19th March 2020

Two storey side extension, part two storey part single storey rear extension, single storey front extension and porch.

27 Meadow Way Ferring

rev	description		date	scale	project	27, Meadow Way Ferring Block Plan
				1:200		
				@ A4		
				drawing number		
A	Side extension to No 29 added	310816		TSH/MW/005		
dm		app		rev.		
date		date		A

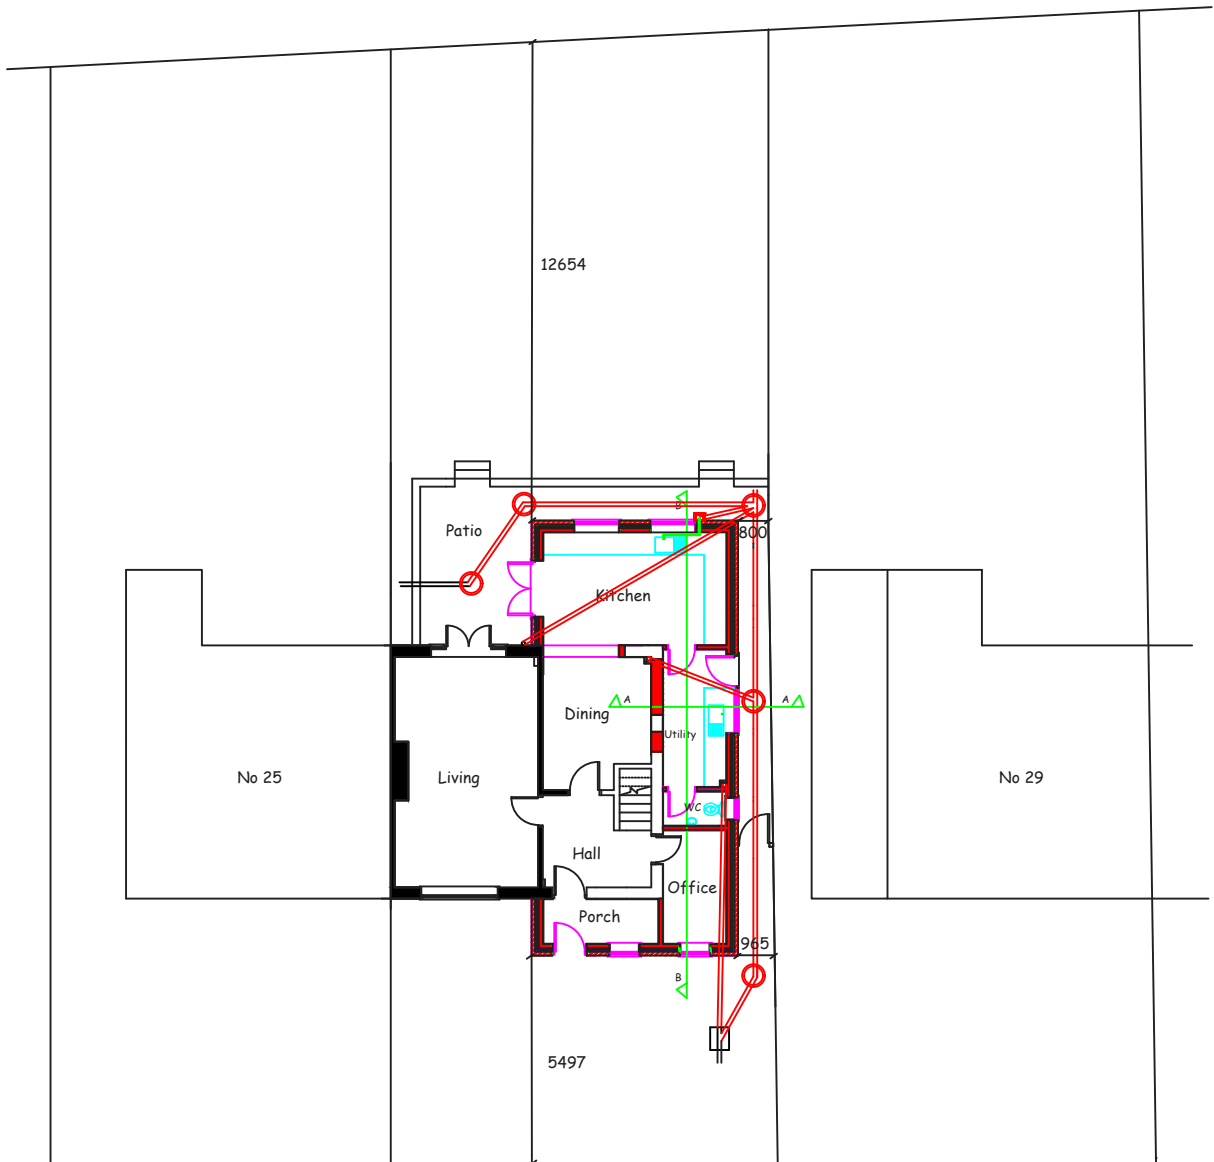
Ferring Parish Council raises concerns on this application which focus on the size and scale of the proposed two storey extension in relation to the host and it's neighbouring properties. The east / west aspects will be overly dominant having significant overbearing impact on the adjacent properties in terms of the scale of visual presence and overlooking of gardens.
